Application SSI 7485 put the people central to the design, maximizing safety, and

I write regarding the proposed modifications to the M4-M5 Link, Mod 2 The Crescent overpass and changes to pedestrian infrastructure in North Annandale, Rozelle and Rozelle Bay and Foreshore area.

**Figure 4 | Proposed modification** (Source: Design Amendment Report)

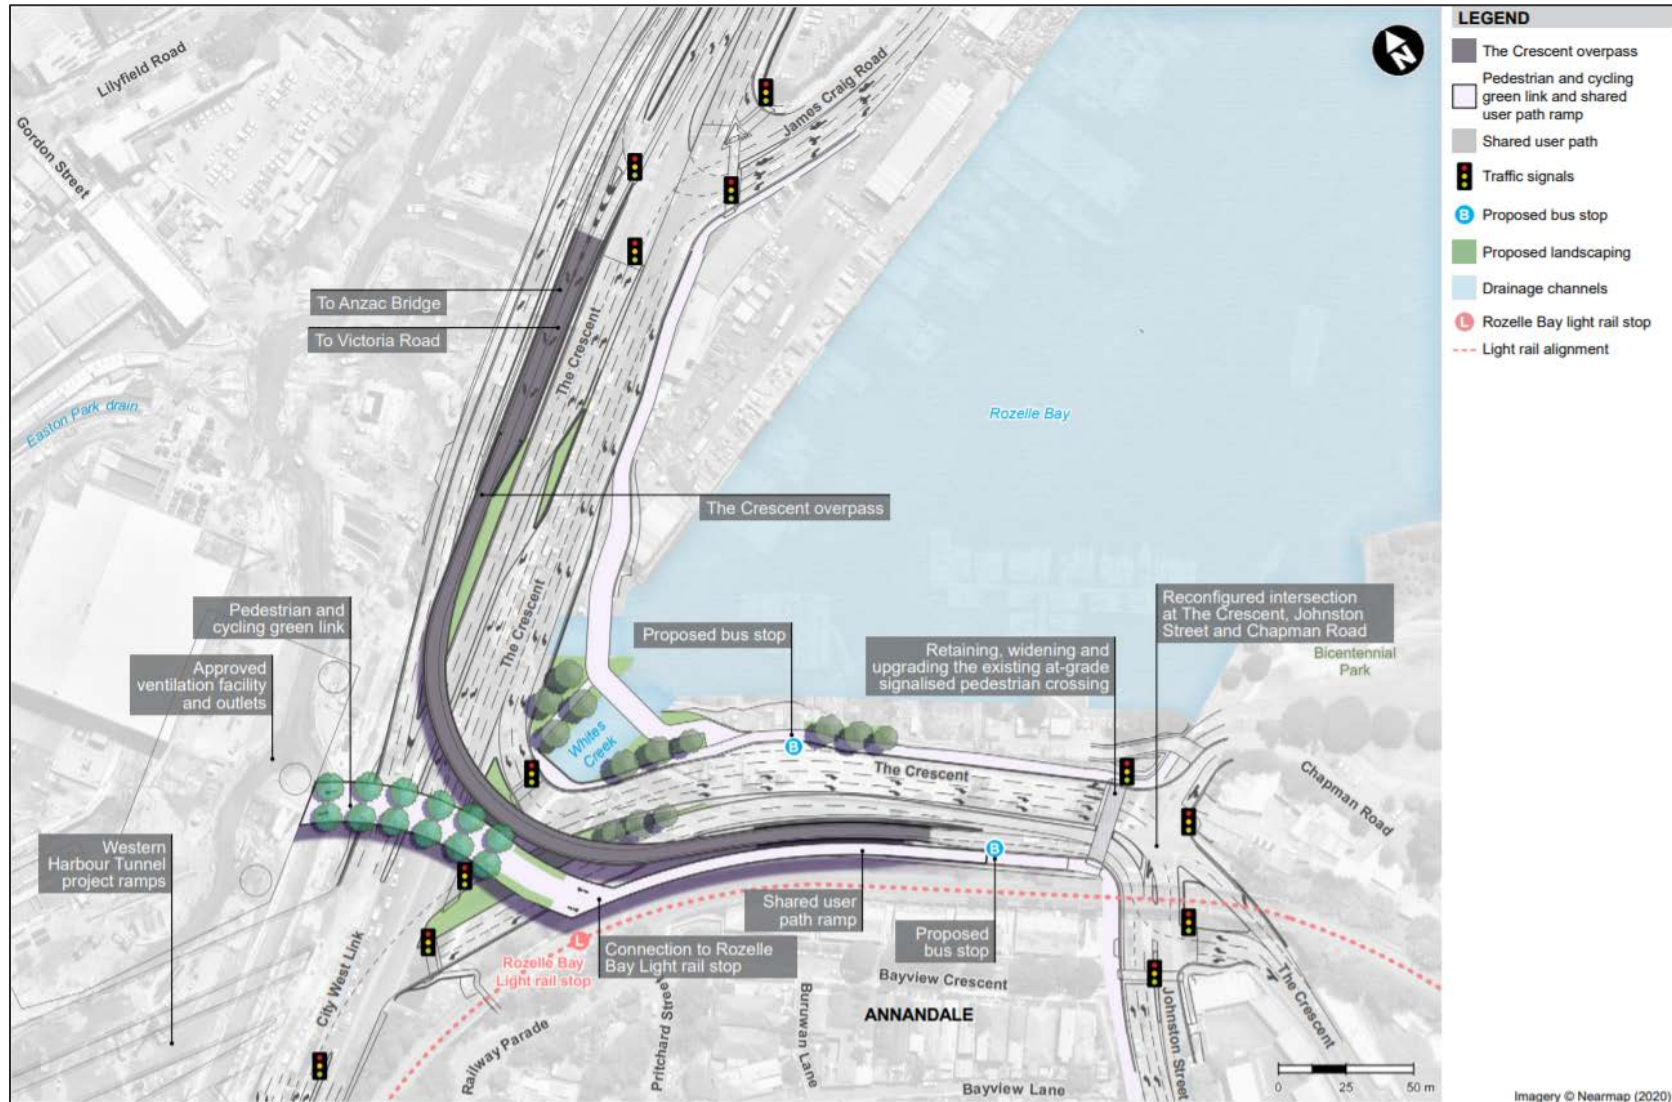
I request RMS work with the community to explore alternate design options to the proposed new car overpass design and the changed pedestrian and cyclist links. I am seeking the reinstatement of the safe, direct access from the approved EIS Greenlink to create a continuous green open space connection from the Rozelle Rail yards and Annandale to the foreshore. The Greenlink was more than just a walk away – it put people central to the design, maximizing safety, and providing much needed accessible open space for the community now and into the future bay's precinct design.

- The significantly reduced safety and increased risk for pedestrians and cyclists with removed access over The Crescent to Bicentennial Park and the increased traffic along Johnson Street
- Being required to cross five sets of pedestrian lights at the crescent as my option to reach the foreshore from Annandale or from Rozelle Bay light rail stop
- Removal of the direct active links to the foreshore, cutting the community off from the area and the proposed revitalisation of the entire Bays Precinct, including linking the Light Rail and Bus Stops to a Ferry wharf and Metro station.
- Urban and landscape design that is being built before a finalised masterplan for the area
- Traffic changes that limit movements around the suburb and create further congestion in the local streets of Annandale, Forest Lodge, Glebe, Lilyfield and Rozelle with no planning to deal with these.

- Lack of view corridor towards the city from the Rozelle Bay Light Rail Station
- Increase of traffic noise from the raised road system (which will be an eyesore!. Have we not learnt from the Cahill Expressway?)

- Integrate active and direct connections to all active transport – including the future metro west and Foreshore ferry wharf
- Furthermore, I suggest reverting to the originally planned road system upgrade and where possible putting the links underground or at the very least on the existing ground plane. The idea of a raised motorway will significantly adversely affect the ambience in and around the crescent, Bayview Cres and Pritchard Street.

A Cahill expressway style of raising the roadway belongs in 1960 NOT 2019. This must be stopped, and a sensible people-oriented interchange needs to be prioritized over the current proposed modification.

- Reinstate the Greenlink connecting communities and green open space from Rozelle to Bicentennial Park.
- Relocate and design pedestrian and cyclist connections that are continuous, safe and direct

- Provide pedestrian and cyclist paths that connect people and parks with a focus on safety and do not force people onto busier (and unsafe) streets, create plazas and caged walkways.
